From: [Downes, Scott G \(DFW\)](#)
To: [Jeremiah Cromie](#)
Subject: RE: RU-22-00005 Kostenich - Transmittal of Comments
Date: Thursday, June 1, 2023 2:35:56 PM

Subject: FW: RU-22-00005 Kostanich - Transmittal of Comments

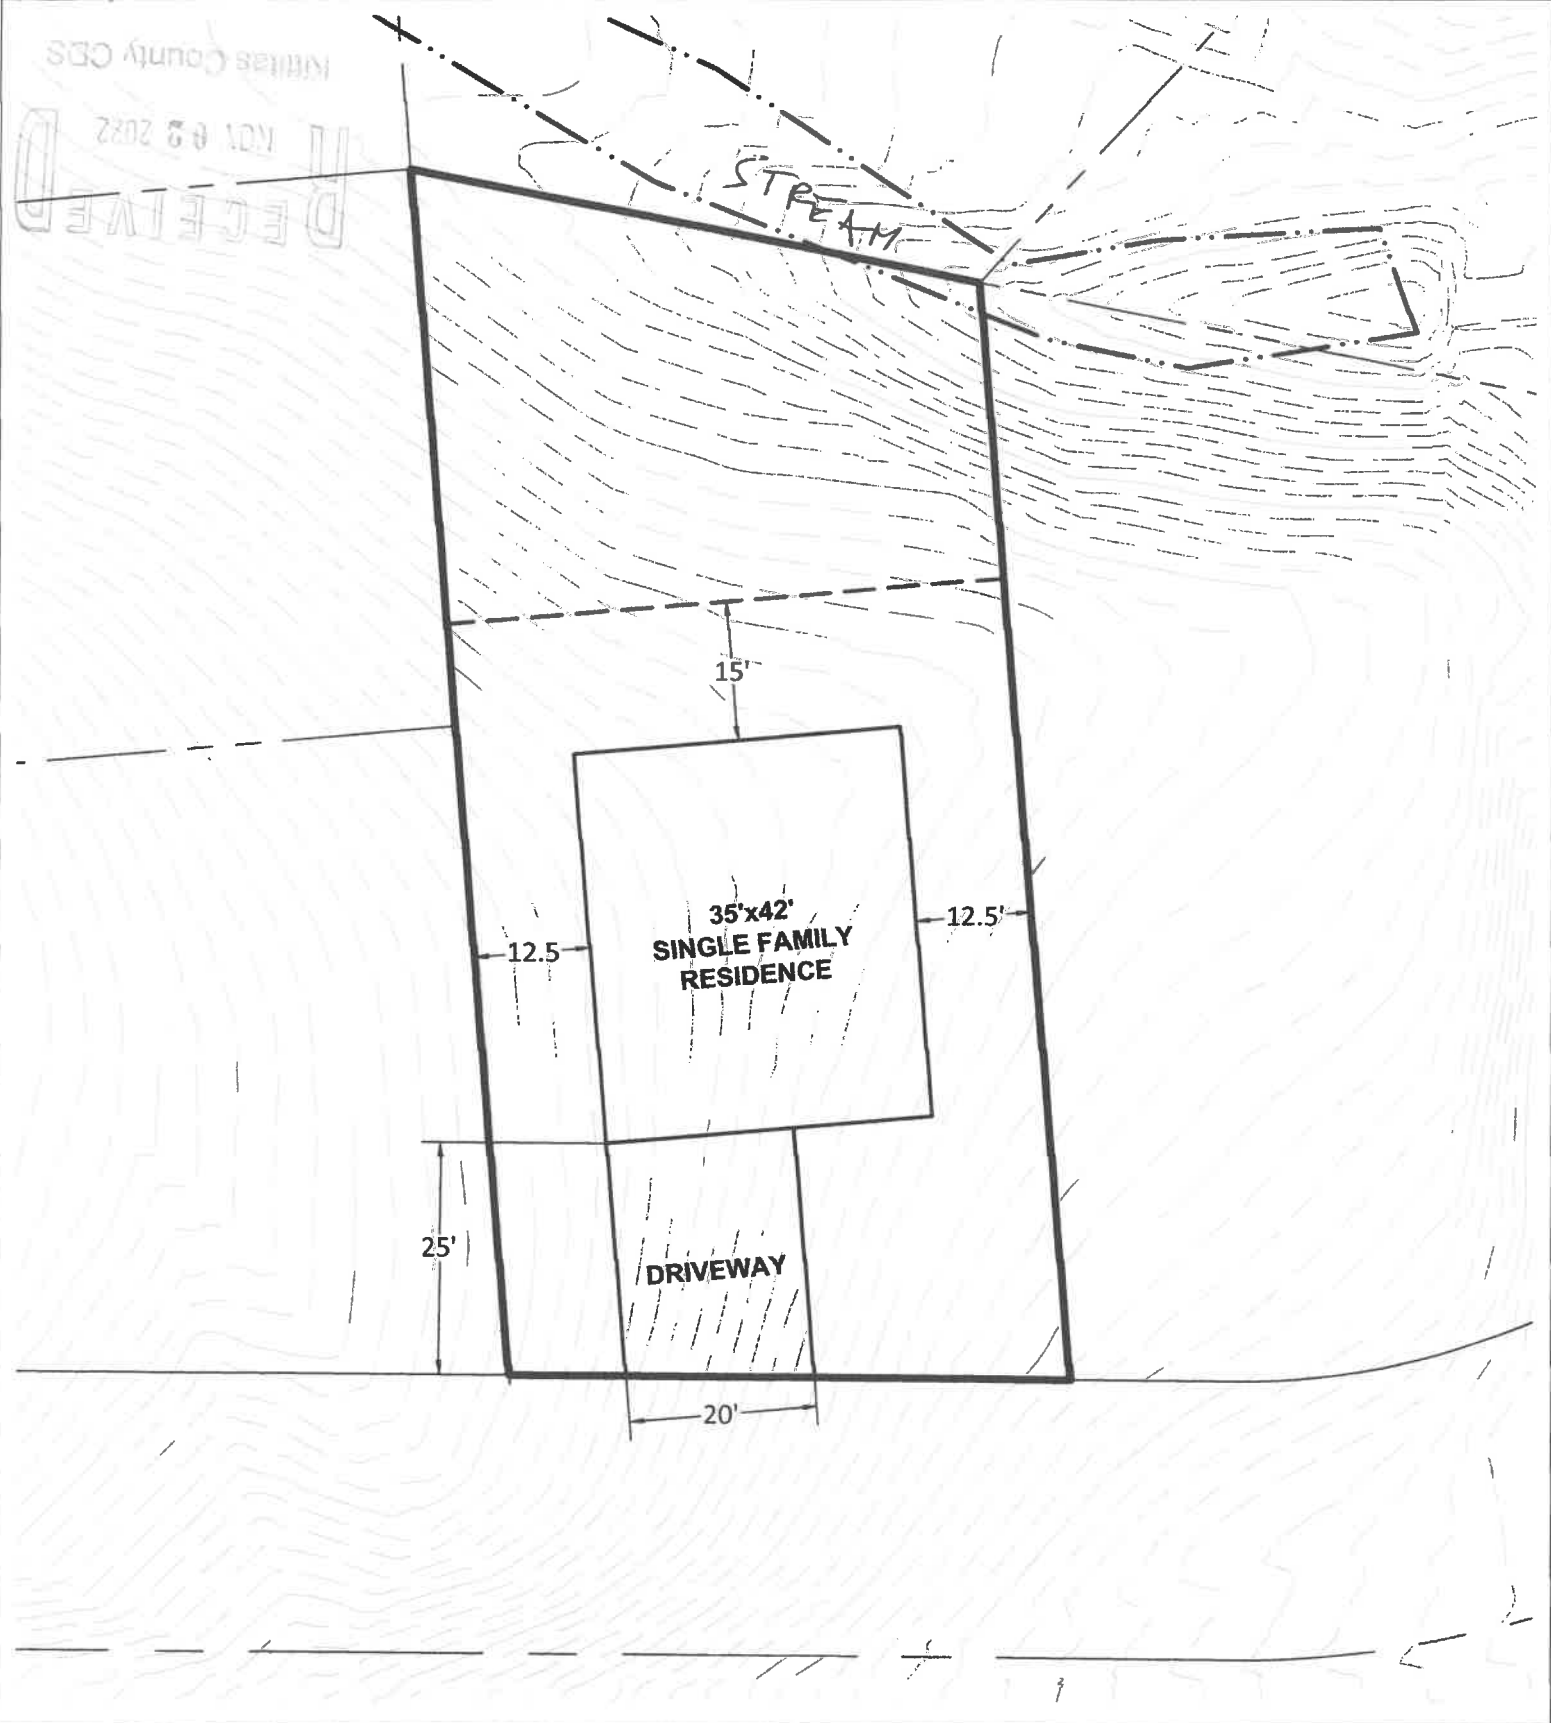
1. What are the size of the trees being removed and where are they located, they mention 12 in the email but don't talk about their size or position to the creek (how much are they contributing to shade of the creek)?

We need to determine shade inputs to the creek. If the current trees to be removed are large and we are only proposing to replant small conifers which only grow about maybe a foot a year, there will be significant impacts in the shade of the stream during the next few decades. It looks like they are only proposing a very small patch of fast growing willow, which likely won't offset shade impacts if they are clearing trees in all of the areas they are replanting. So, we need some solutions for the loss of shade. Are they ok with leaving some of the trees nearest to the stream that are contributing the most to the shade? Is placing some of the trees in the creek as a means for shade (like we did at adjacent Ski Acres-maybe work with the owners there if they control the creek area)?

1. We changed the monitoring duration to 10 years hoping we can reduce that timeline with positive results after the first few years.
2. We added new willow plantings.

3. We've increased the new conifer tree plantings from 12 to 25. We're unsure how many trees will be removed with our current estimate at 12. We plan to replace at least as many as we need to cut.
